Our Ref: BR/75/20/HH
Your Ref:

Town & Country Planning Act 1990 (as amended)
Town & Country Planning (Development Management Procedure) (England) Order 2015
Application for Planning Permission for Works or Extension to a Dwelling

Development Conversion of roofspace to habitable use to include a rear dormer and terrace, with front and side rooflights
Location 140 London Road Bognor Regis

PROPOSED ROOF PLAN
SC. 1:50

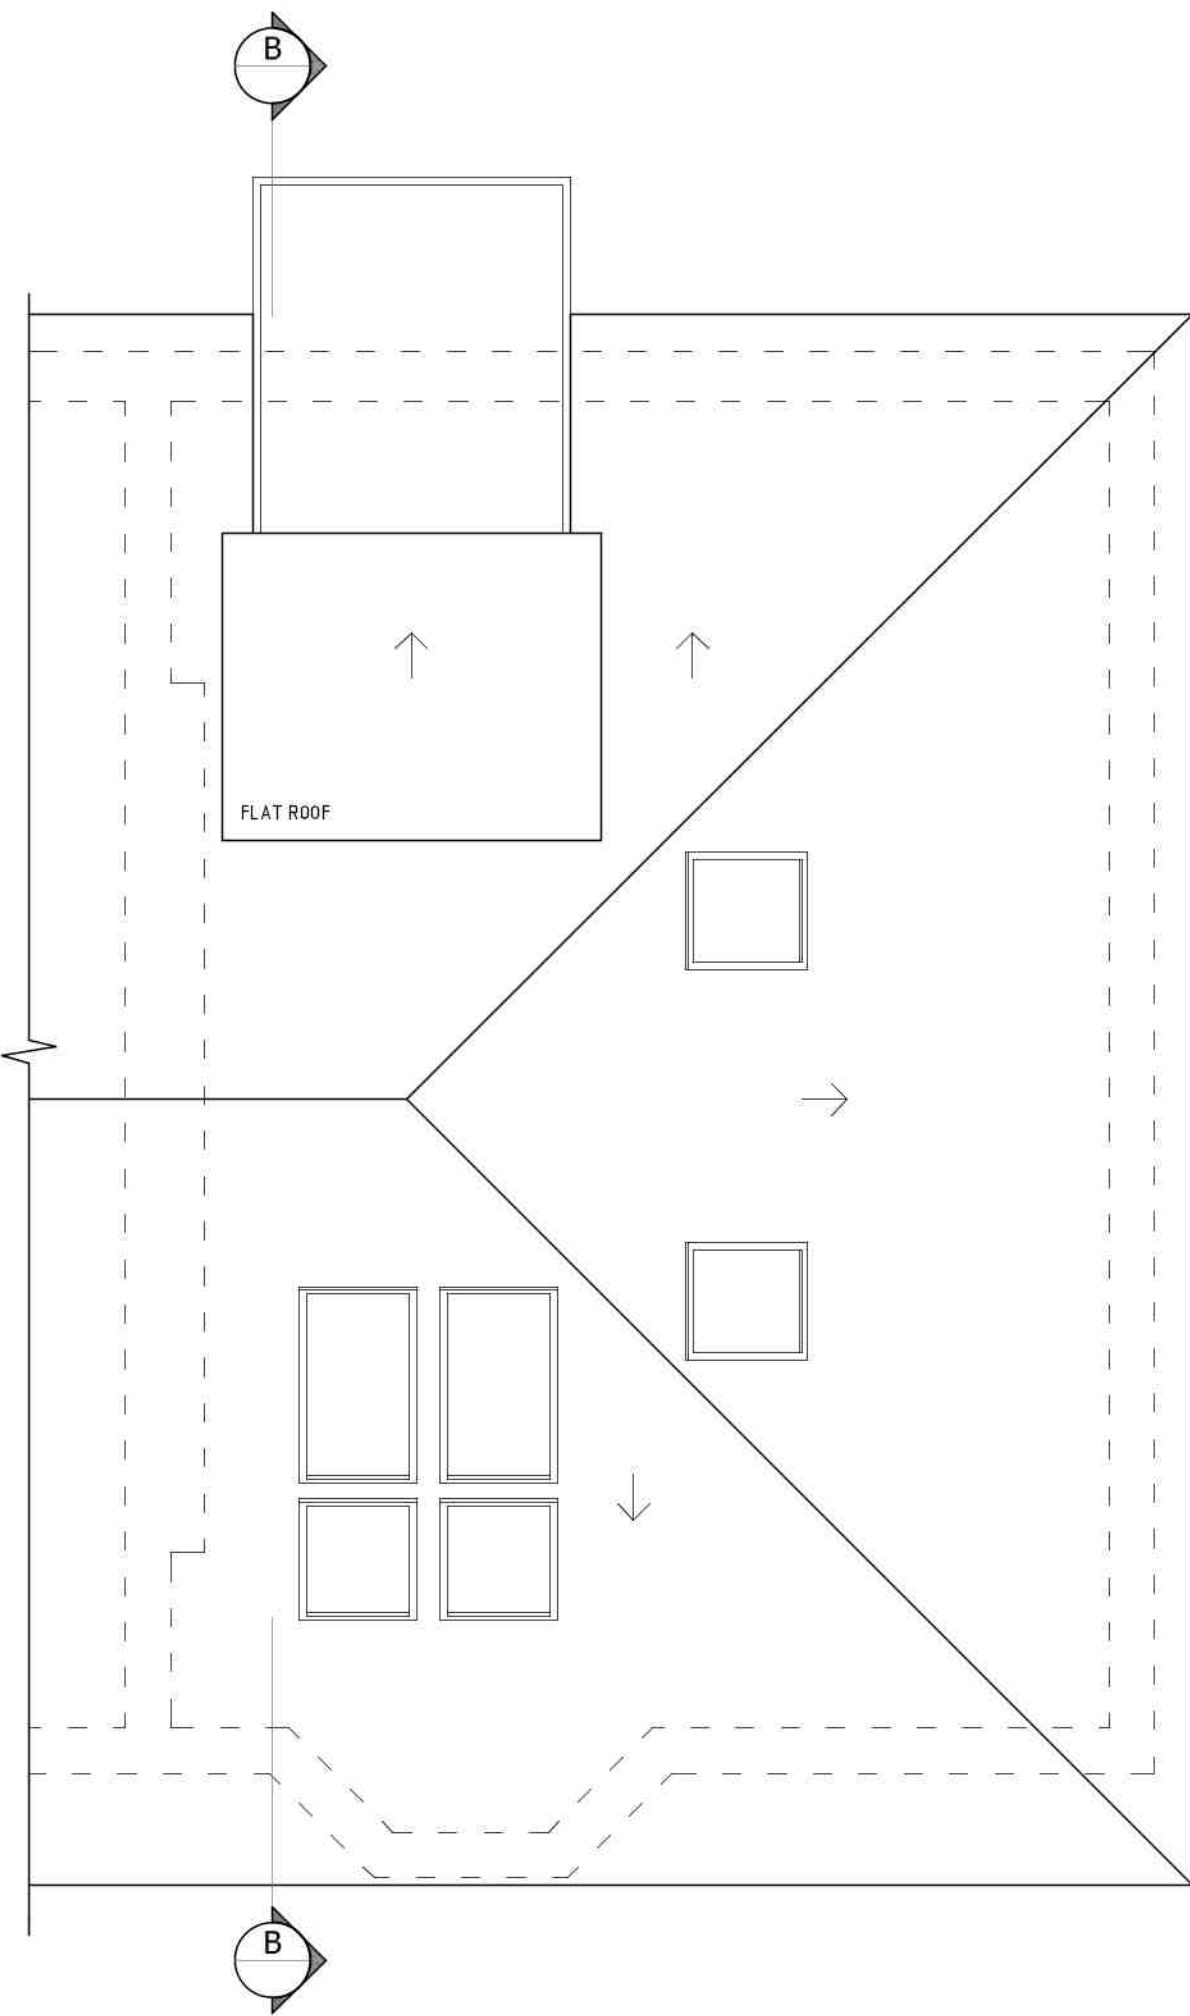
Roof Plan

The proposed roof plan is labelled 'existing' and doesn't show the rooflights shown on the elevations.
